# Rezoning Transportation Analysis

Petition Number: #2022-096

## Revision Log:

Date	Description
11-28-22	First Review (TM)
6-21-23	Second Review (DR)

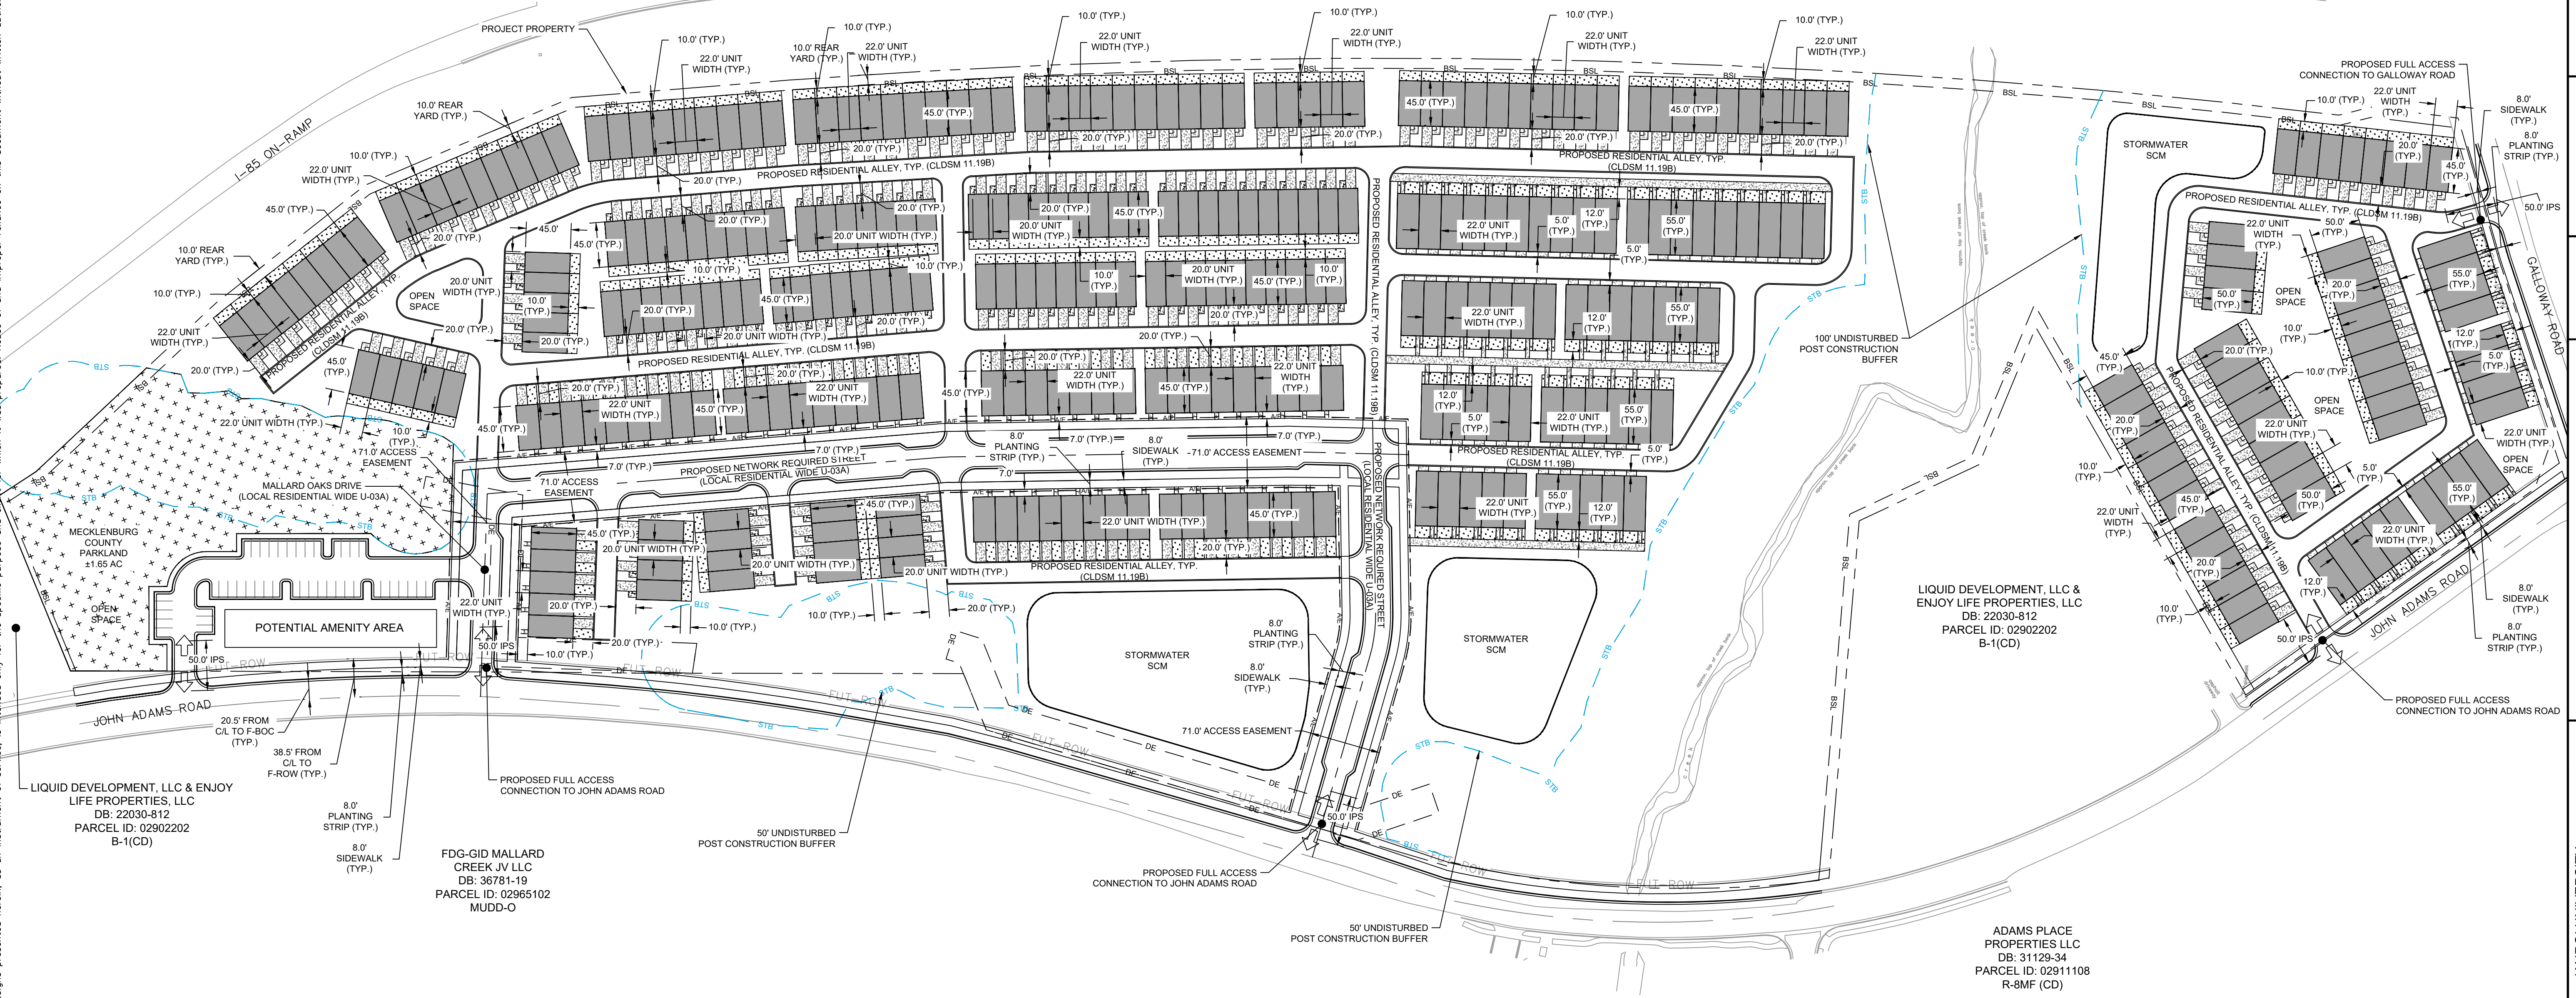
**Clarifying comment 6.21.2023:** Label and dimension 8-foot planting strip and 8-foot sidewalk on John Adams Road.

- The proposed dwelling units exceeds 12 per acre. Per Chapter 20 Subdivision ordinance, site plan and conditional note(s) revisions are needed to commit to construct an 8-foot planting strip, and 8-foot sidewalk along John Adams Road, Galloway Road and all internal network required public Streets. The wider sidewalk also meets the Charlotte WALKS Policy.

**Clarifying comment 6.21.2023:** Label and dimension 8-foot planting strip and 8-foot sidewalk on all internal public streets.

- Conditional note(s) revisions are needed to commit to correcting grade break issues along John Adams Road. Add conditional note to commit to this improvement along John Adams Roadway.

- New Comment 6.21.2023:** Label and dimension internal channelization (internal protected stem) and ensure that each driveway provides a minimum 50 feet. No parking shall be allowed within the minimum 50 feet of internal channelization.
